**City of Portland, Maine – Building or Use Permit Application** 389 Congress Street, 04101, Tel: (207) 874-8703, FAX: 874-8716

DATE: 03 OCT. 2000 ADDRESS: 62 Lincoln St CBL: 125-D-003  
 REASON FOR PERMIT: 16'x10' second Floor deck  
 BUILDING OWNER: Victoria Lasbury  
 PERMIT APPLICANT: \_\_\_\_\_ /CONTRACTOR Nat Towp  
 USE GROUP: R-2 CONSTRUCTION TYPE: 53 CONSTRUCTION COST: \$40000 PERMIT FEES: \$4800

REASON FOR PERMIT: 10' x 16' 2<sup>nd</sup> floor deck

PROPOSAL DRAWING FOR
62 LINCOLN ST.
LASBURY RESIDENCE

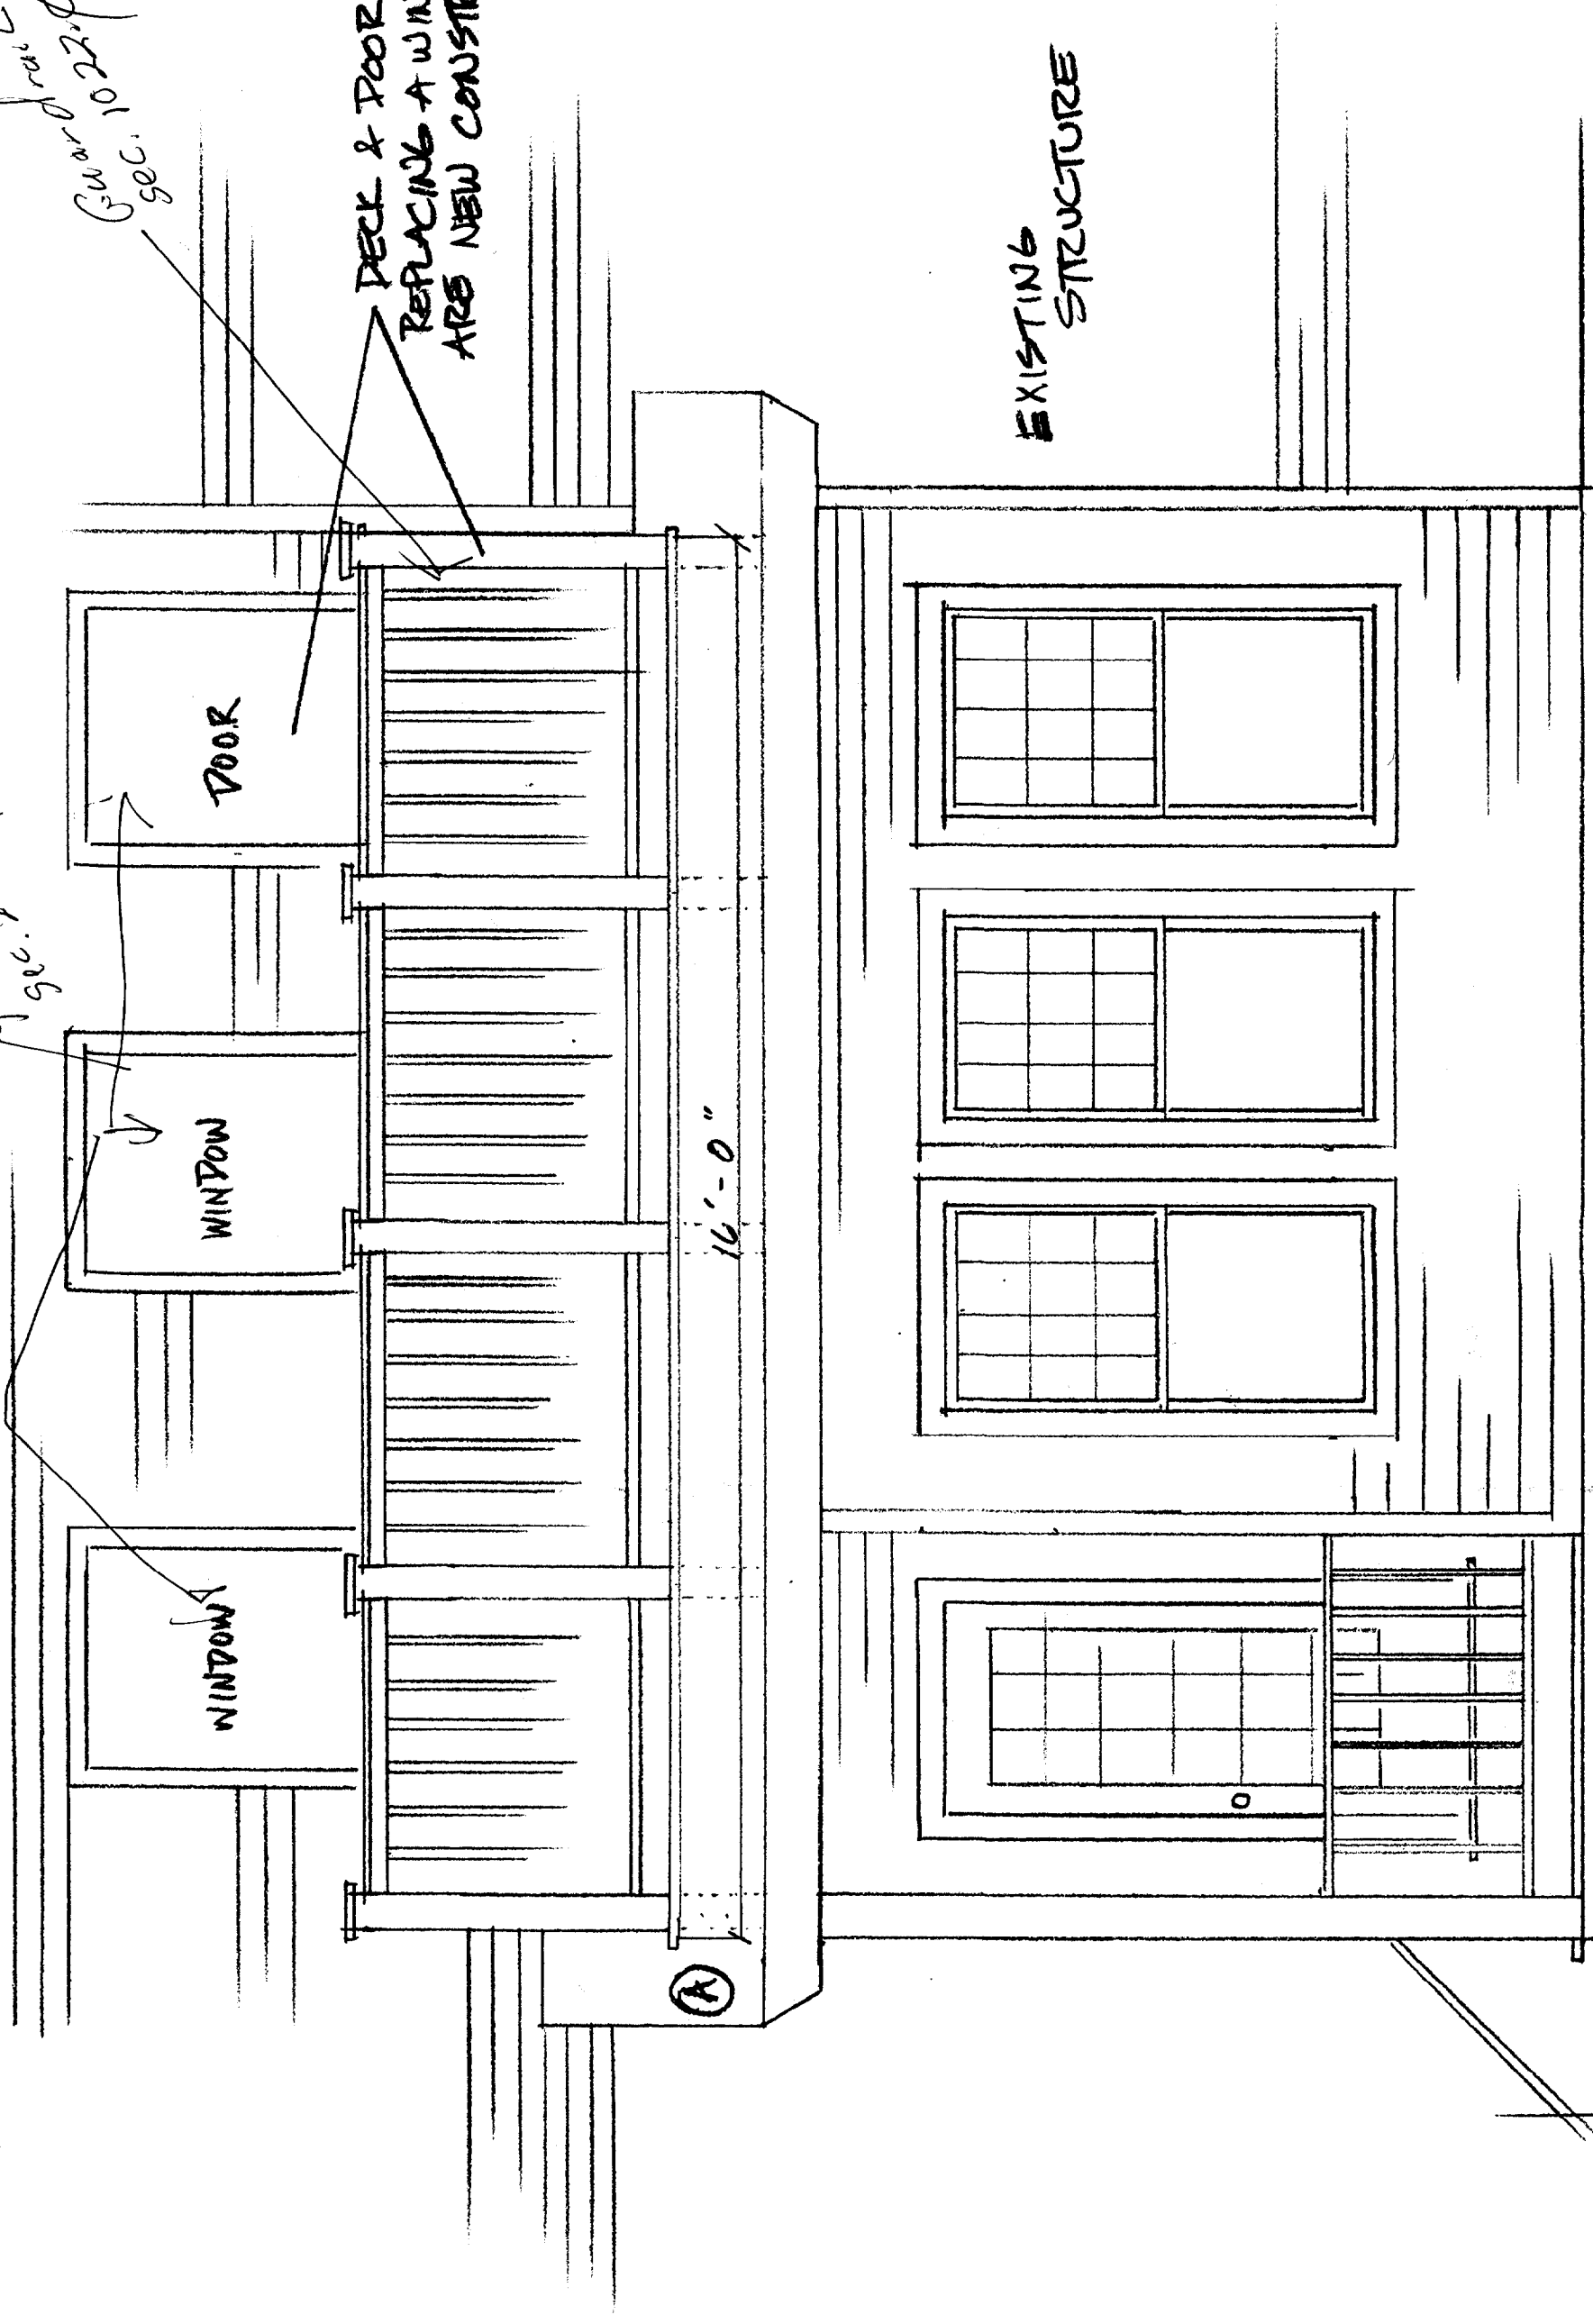
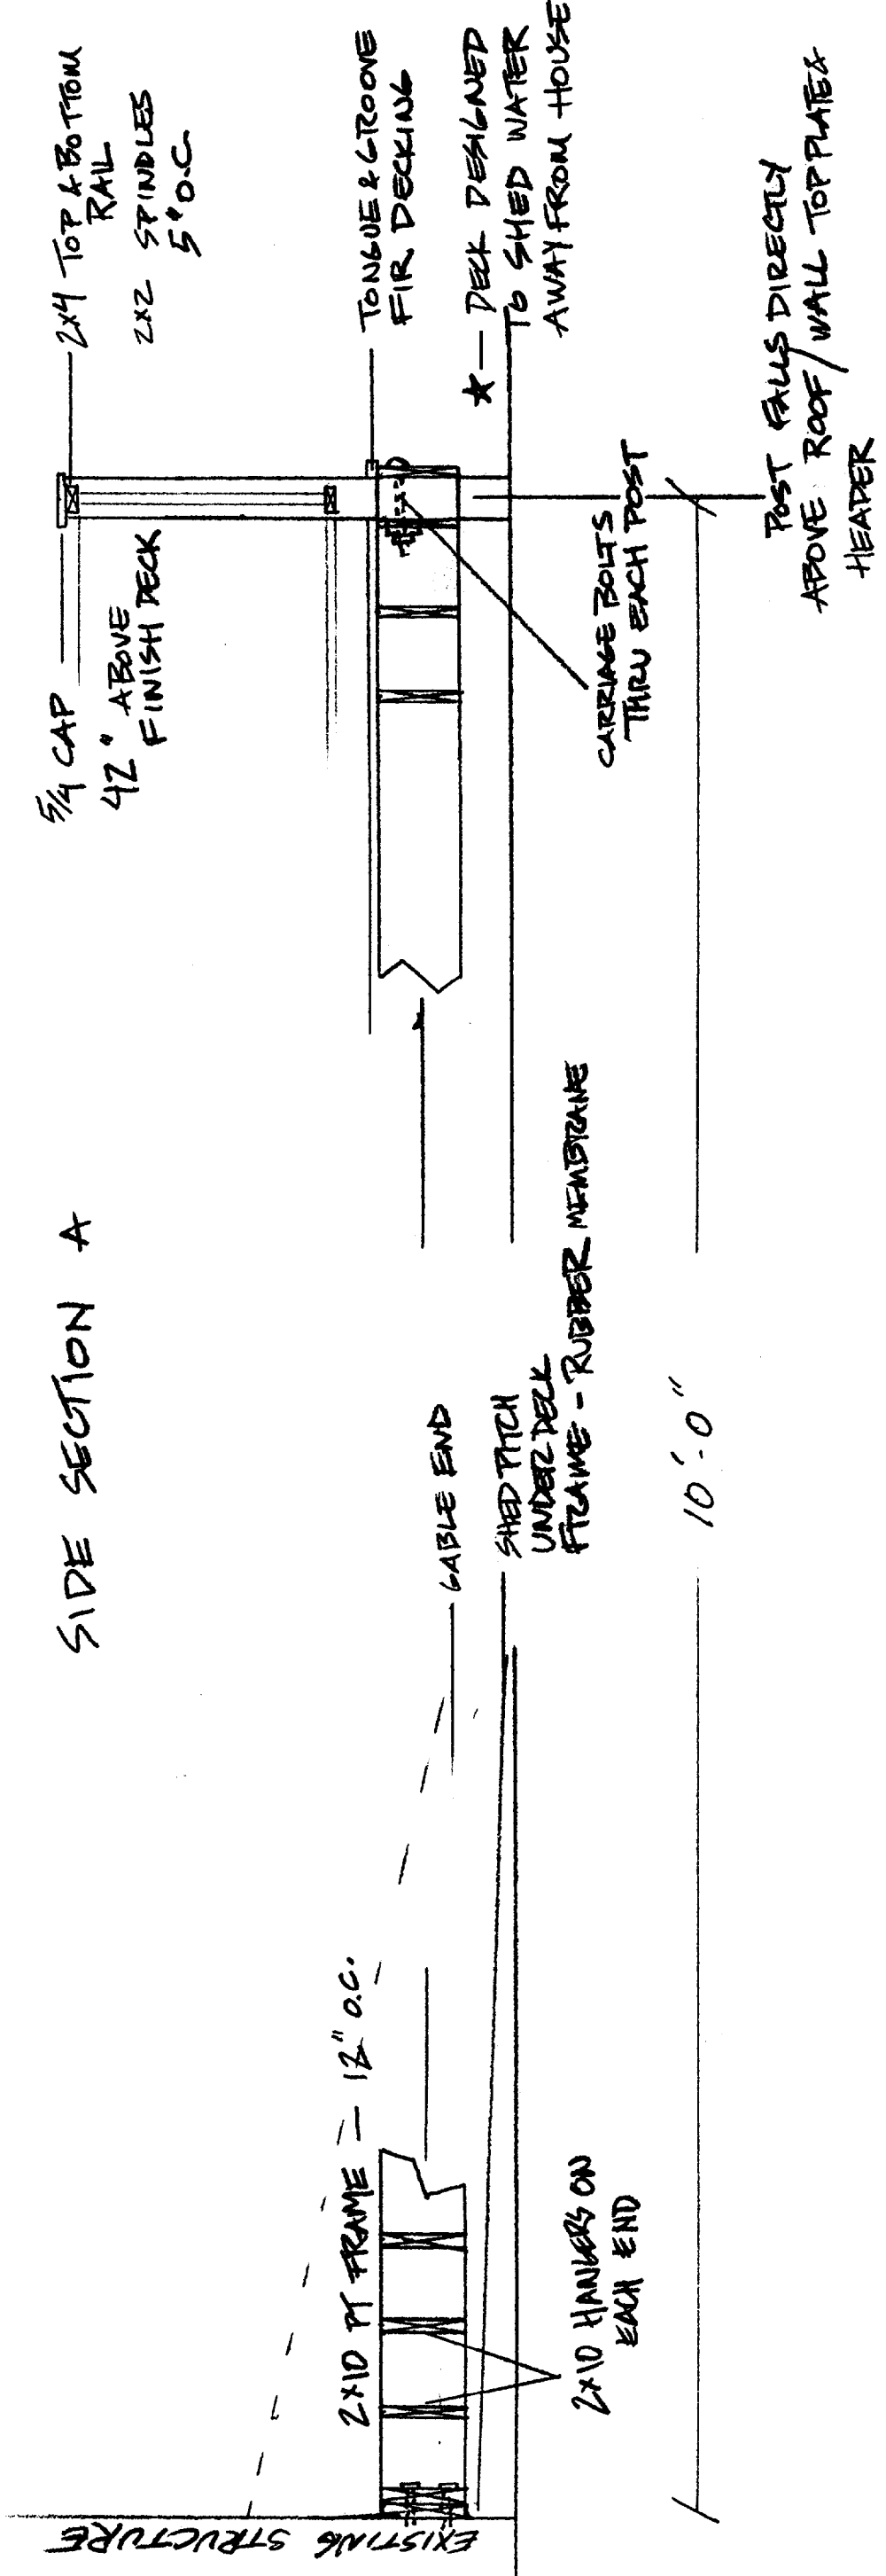
10. Sound transmission control in residential building shall be done in accordance with Chapter 12, Section 1214.0 of the City's Building Code.
- ✓11. Guardrails & Handrails: A guardrail system is a system of building components located near the open sides of elevated walking surfaces for the purpose of minimizing the possibility of an accidental fall from the walking surface to the lower level. Minimum height all Use Groups 42". In occupancies in Use Group A, B.H-4, I-1, I-2, M, R, public garages and open parking structures, open guards shall have balusters or be of solid material such that a sphere with a diameter of 4" cannot pass through any opening. Guards shall not have an ornamental pattern that would provide a ladder effect. Handrails shall be a minimum of 34" but not more than 38". Exception: Handrails that form part of a guard shall have a height not less than 36 inches (914 mm) and not more than 42 inches (1067 mm). Handrail grip size shall have a circular cross section with an outside diameter of at least 1 1/4" and not greater than 2". (Sections 1021 & 1022.0). Handrails shall be on both sides of stairway. (Section 1014.7)

31. Please read and implement the attached Land Use Zoning report requirements. *See Attached*
32. Boring, cutting and notching shall be done in accordance with Sections 2305.3, 2305.3.1, 2305.4.4 and 2305.5.1 of the City's Building Code.

11. Other requirements of condition There shall be no stairways from this deck to the ground.
